Please ask for: Ms Iqraa Malik
Email: iqraa.malik@terraquest.co.uk
Telephone: 0121 234 1390
Our Ref: CM/28/22/HH
Your Ref:
Date: 26th May 2022

Application for Planning Permission for Works or Extension to a Dwelling

Development: Roof lights to rear with dormer onto new balcony
Location: 15 Crothorne Drive Climping BN17 5GG

DRAWING TITLE:
Conservatory Conversion

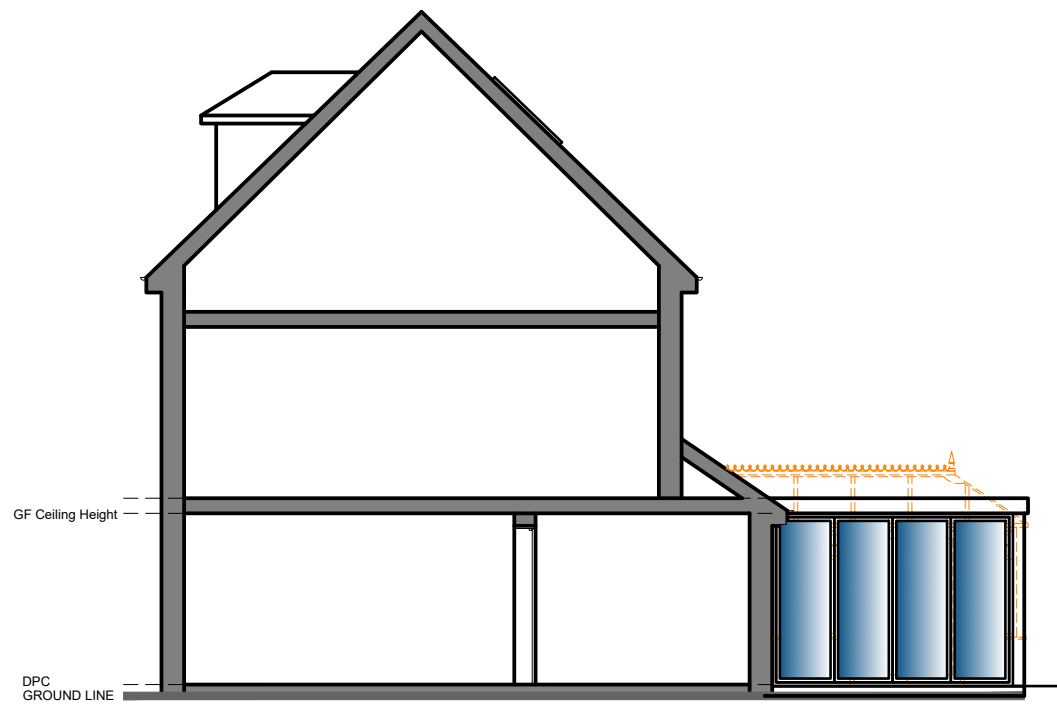
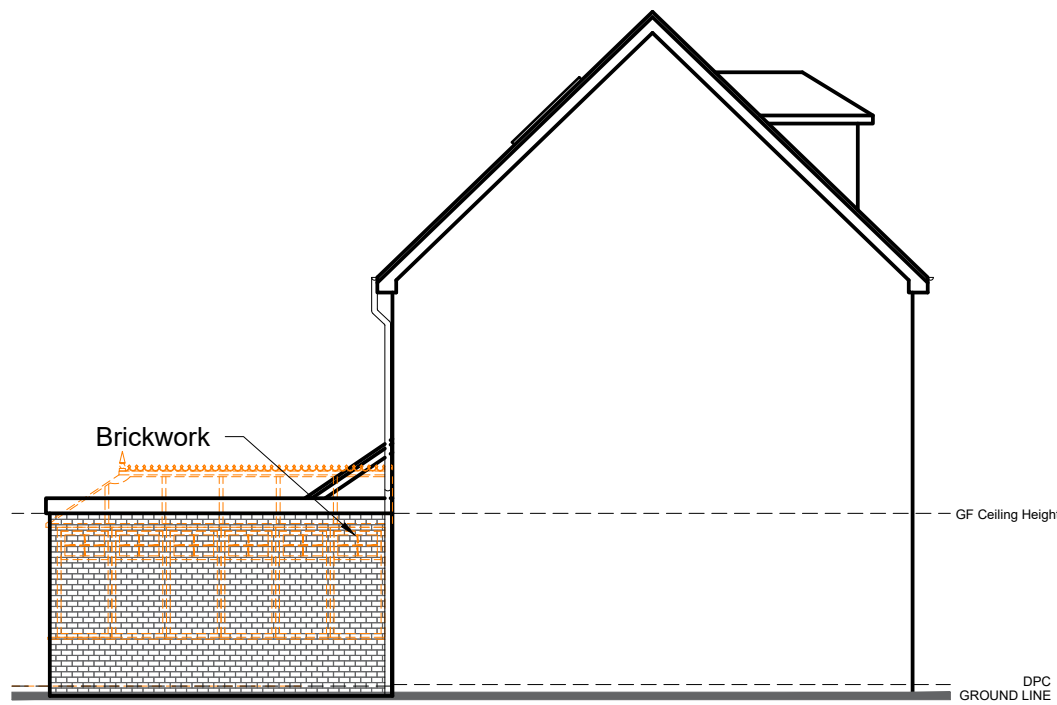
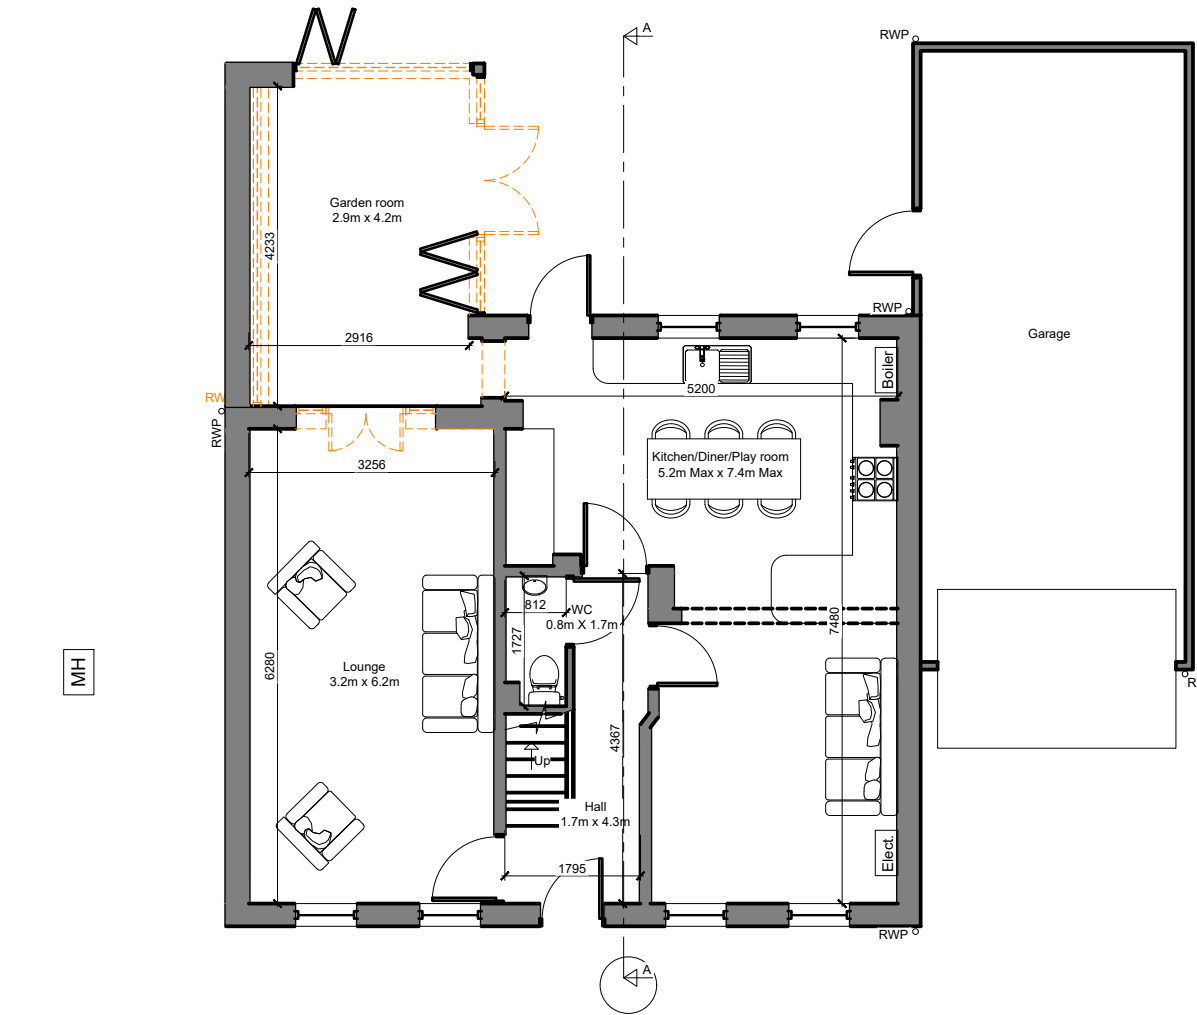
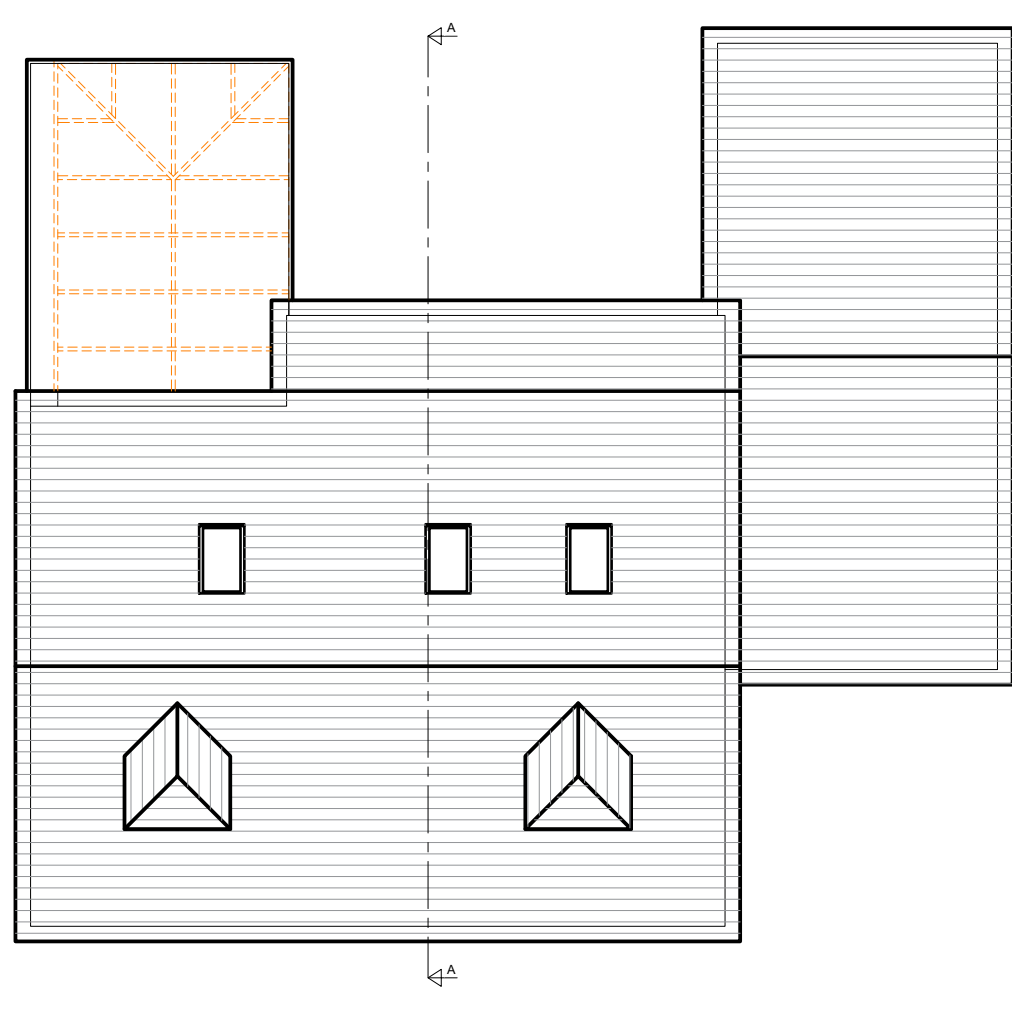
Please confirm the proposed works as you have stated on the application form that you are applying with rooflights to rear with dormer however the plans display a conservatory conversion.
